# Struthers Ranch Subdivision Filing No. 5 Traffic Impact Study

MAY 14, 2021

LSC #204110  
PCD File No. VR-2101

- = 590' Required Sight Distance
- - - = Line of Sight for 590' of Intersection Sight Distance

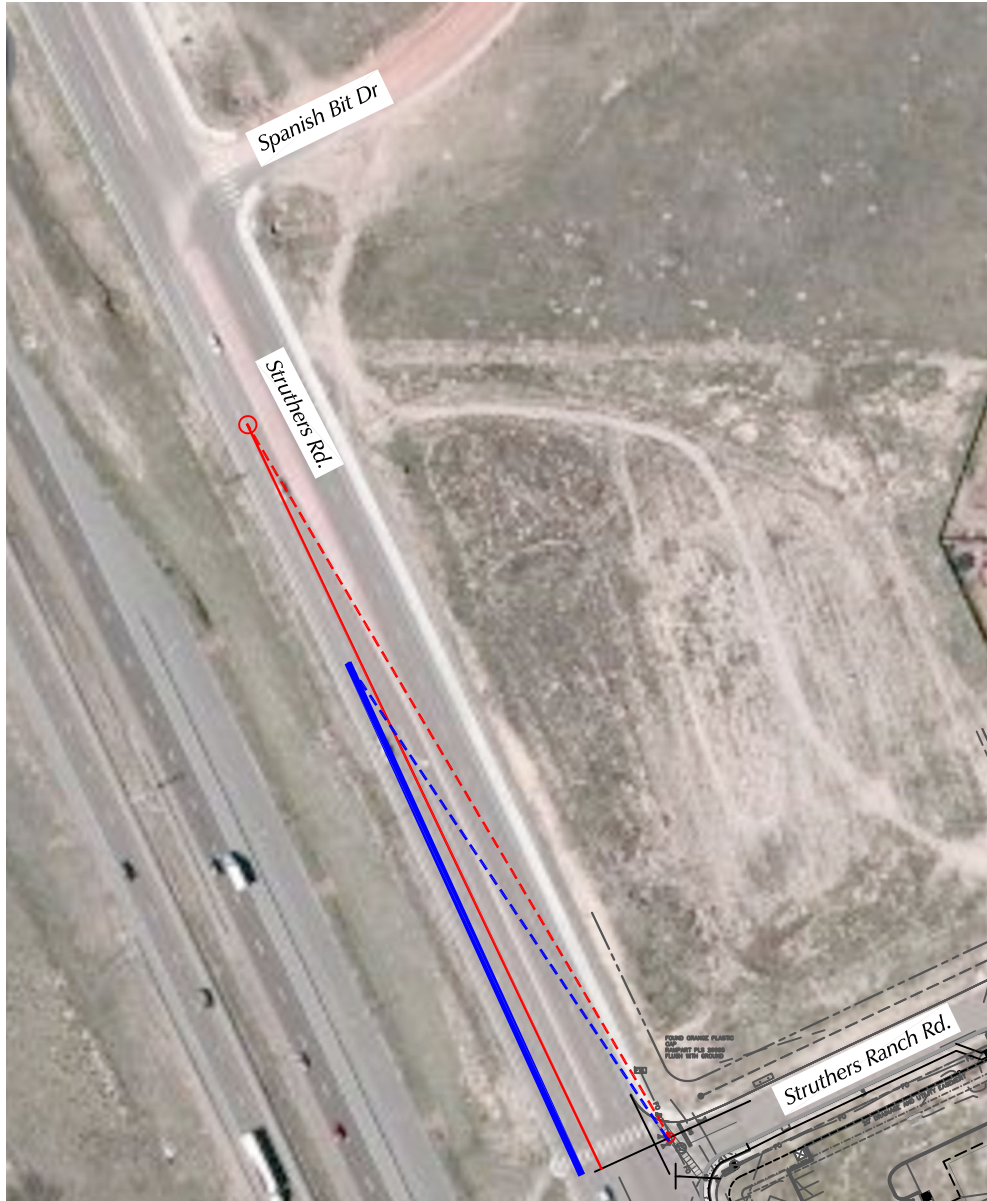
Provide more information on what obstructions are on Struthers Road that limit calculated sight distances from being met.

Provide a deviation request for not meeting sight distance. Provide justification in the deviation request why sight distance is not being met and provide recommendations/alternates as well.

Update the line of sight exhibit to include the single unit.

Identify the time gap used to calculate the sight distance for the single unit truck.

Quantify. Identify the recommended value of truck driver eye height for design.
